June 22, 2021

Reference: Engineering Services
Forest Ridge – Lot 30
Cameron, NC
TE&D Project No.: 2101-020489

As requested by the client, a representative of Tyndall Engineering & Design, PA (TE&D) was on-site to inspect the following items:

# Foundation Plan

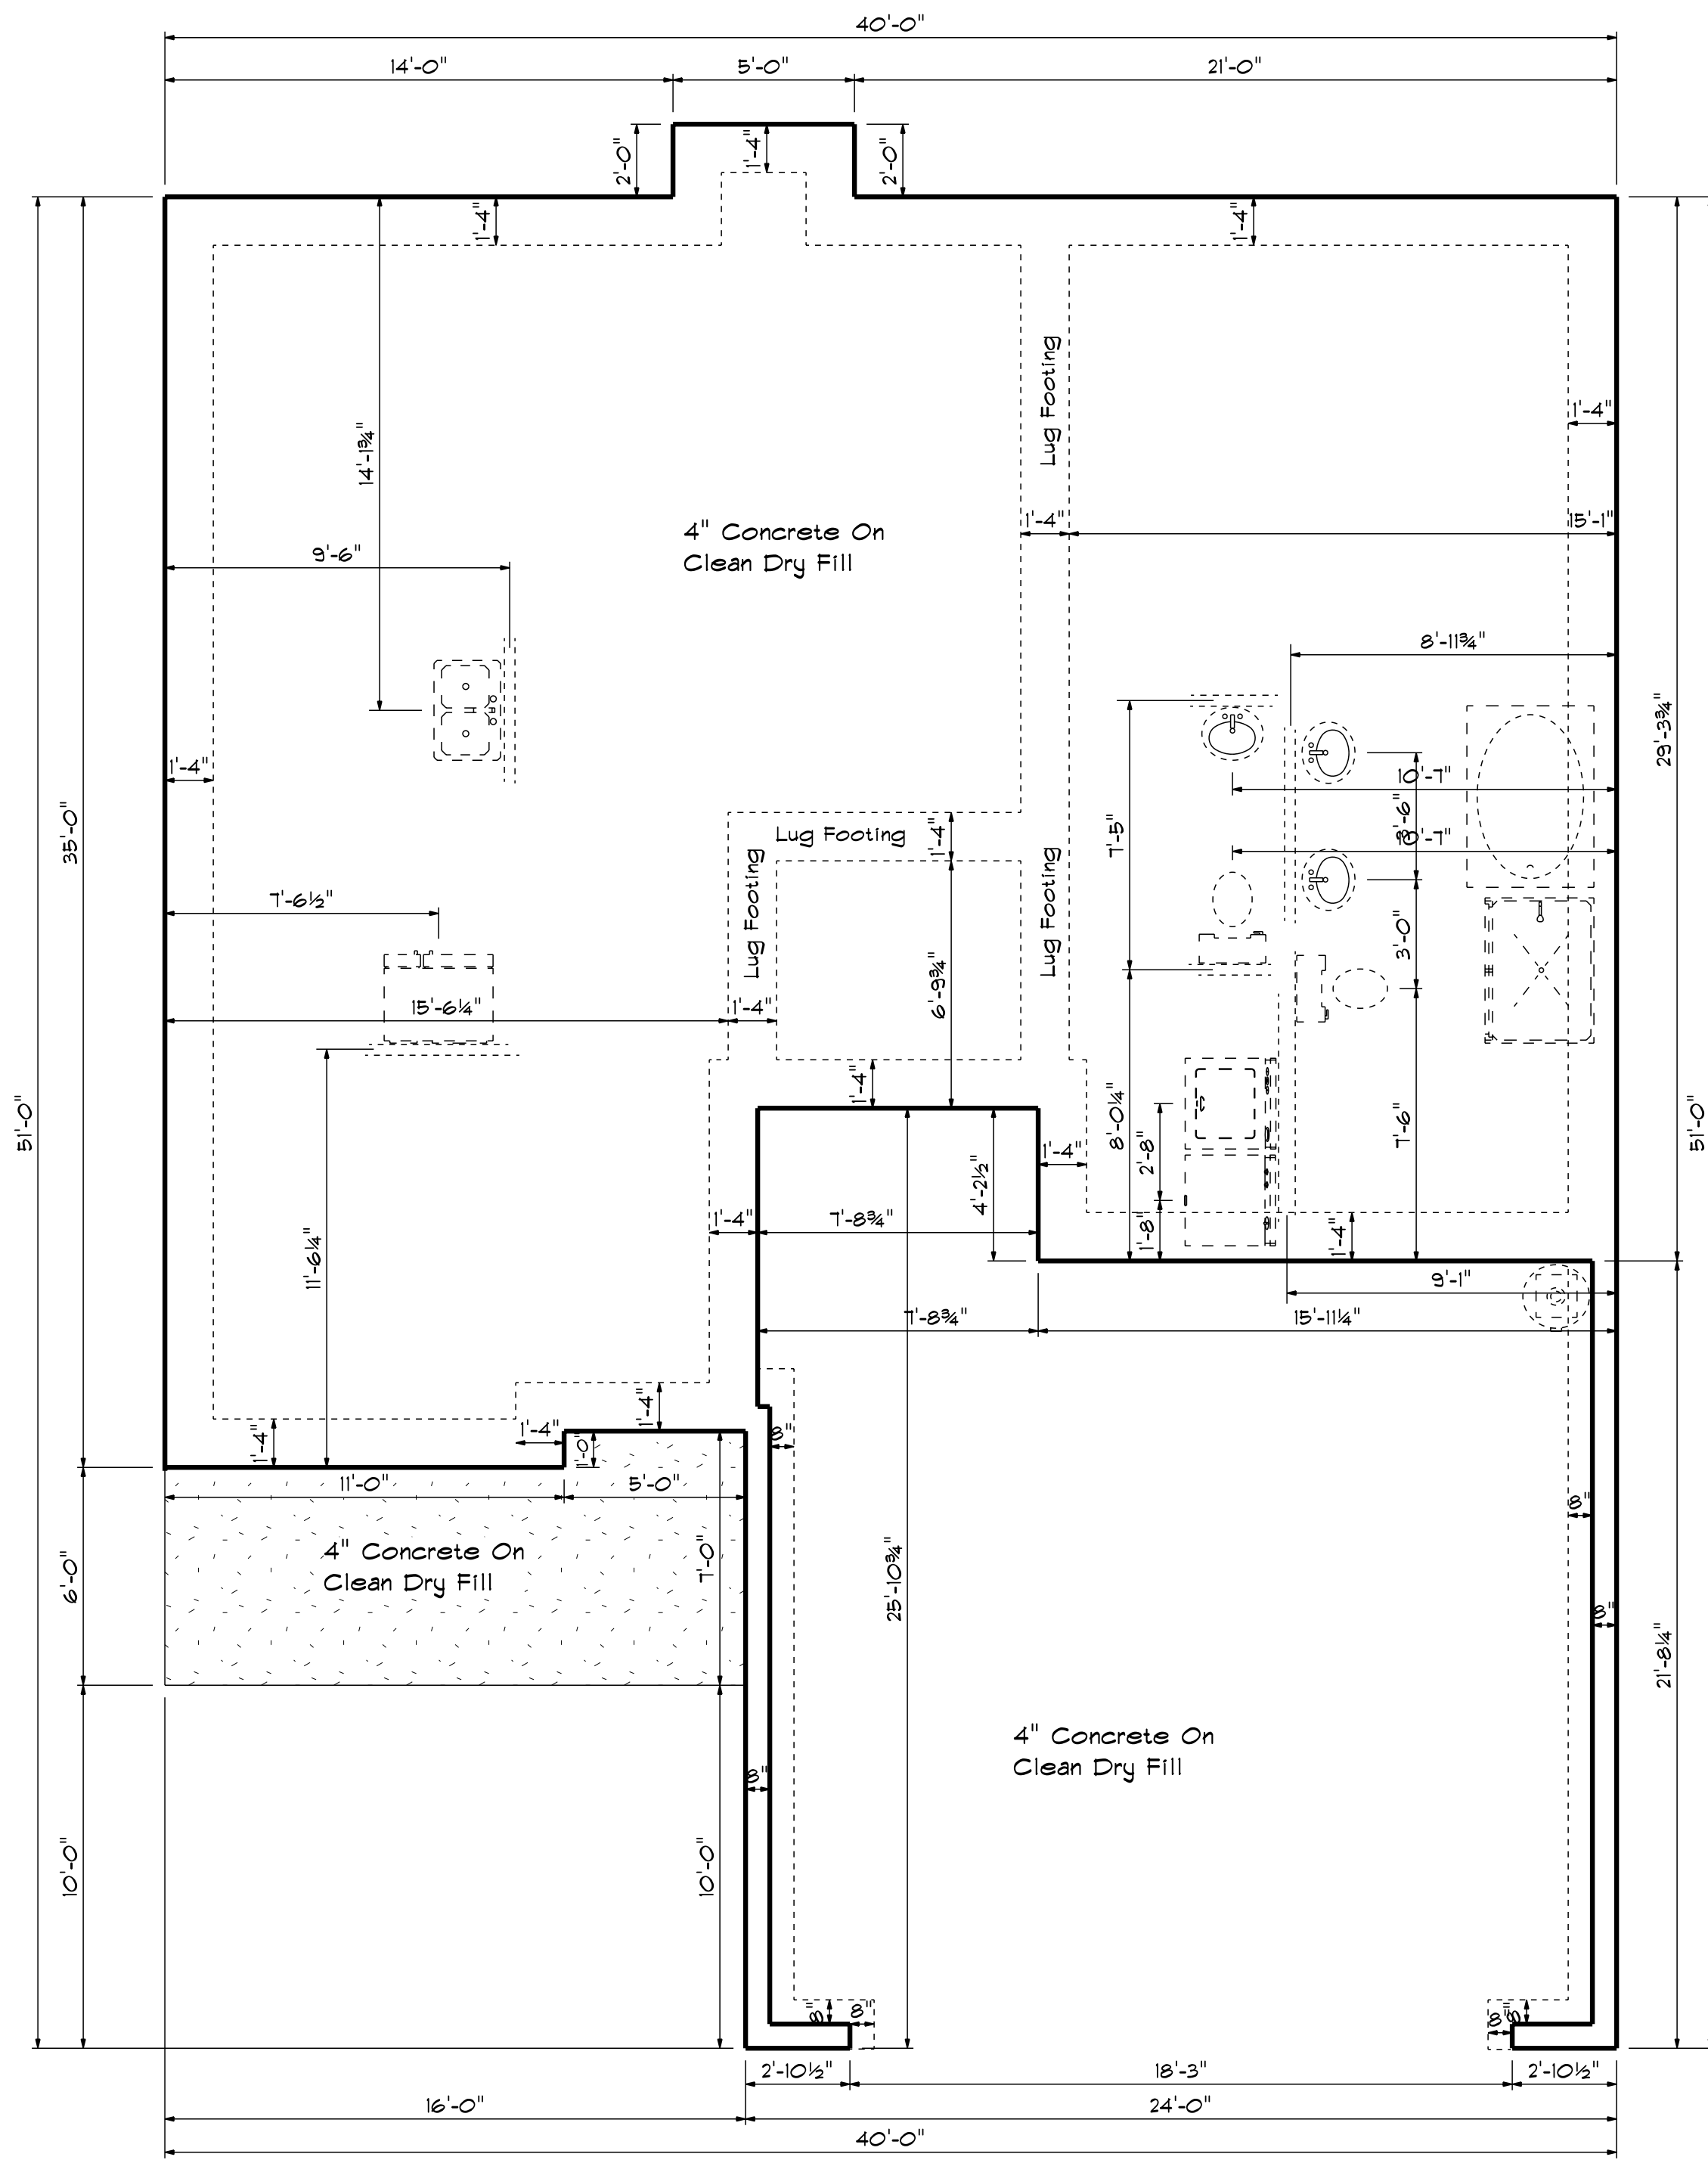
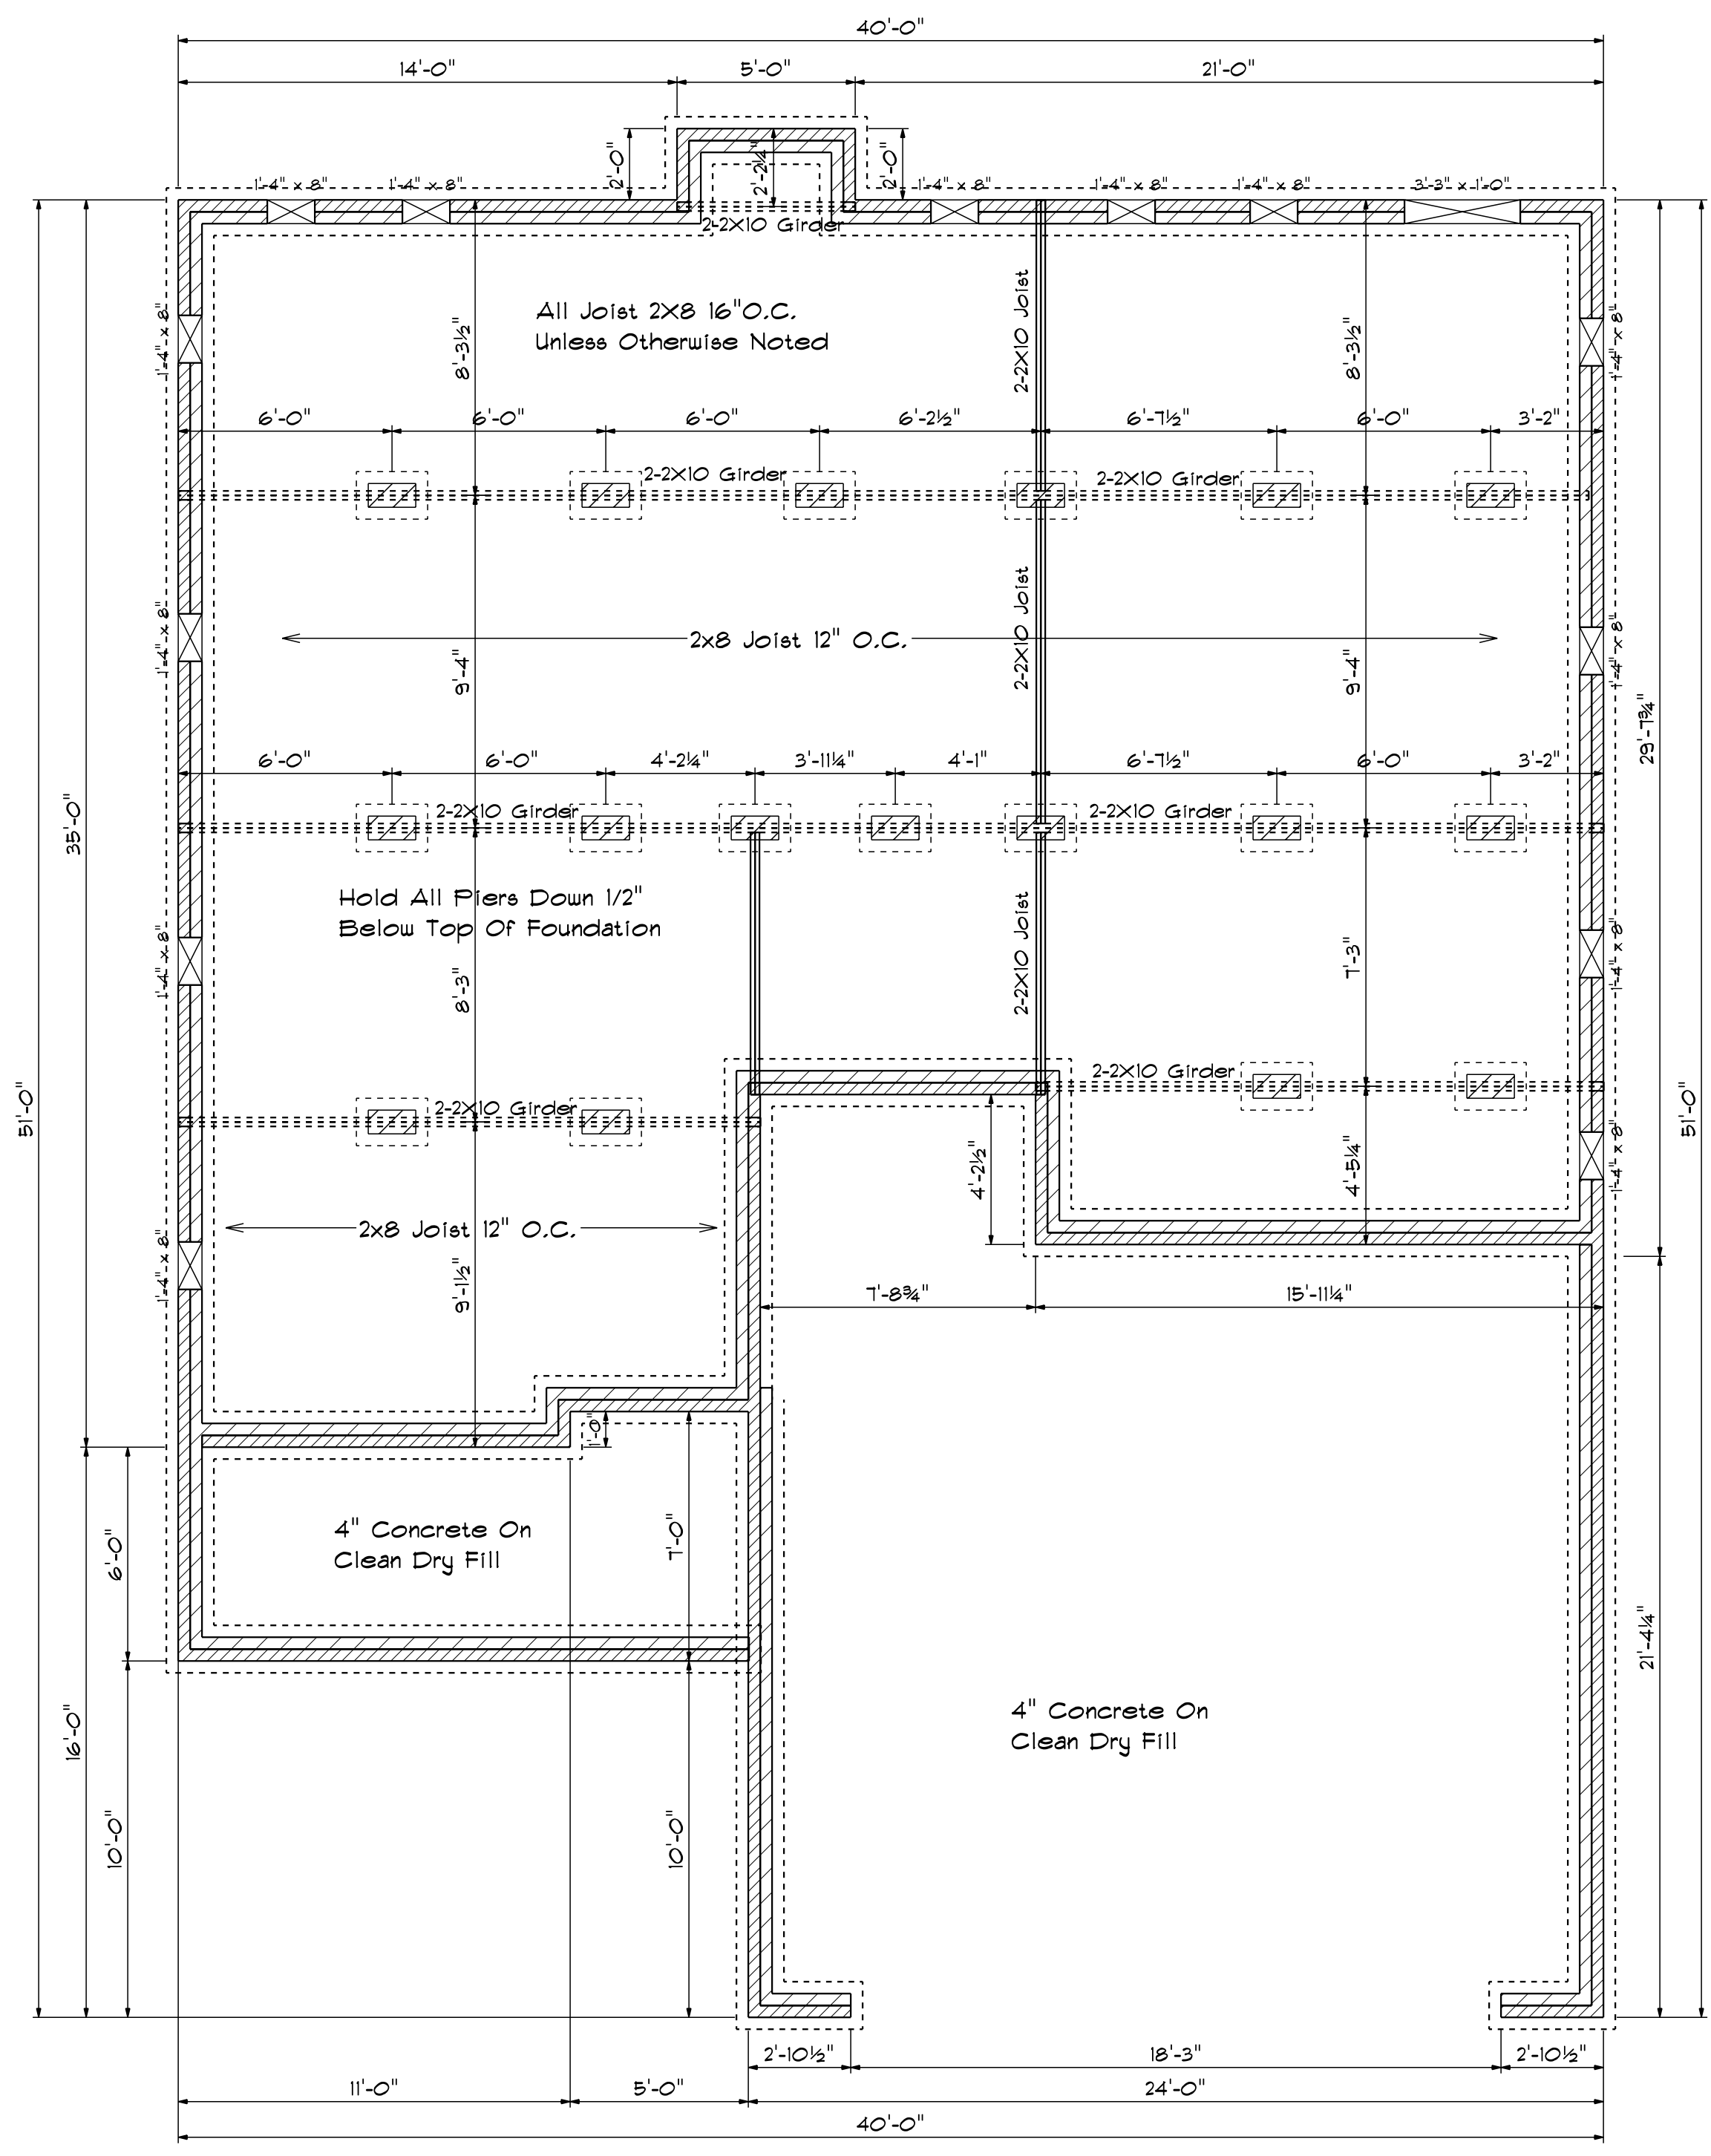
1. Analyze and inspect the projection issues at the interior of the stemwall foundation walls. Areas observed were at various locations at the left, rear, and right foundation walls.

1. Based on our observations and analysis, the areas lacking projection are to be repaired by excavating a minimum 8” wide trench to the bottom of the footing and installing (1) row of #4 x 8” rebar dowels at 16” o.c. Dowels are to be horizontally embedded a minimum 4” with epoxy. Upon completion, the new sections of concrete will provide the required support for the anticipated loading conditions.
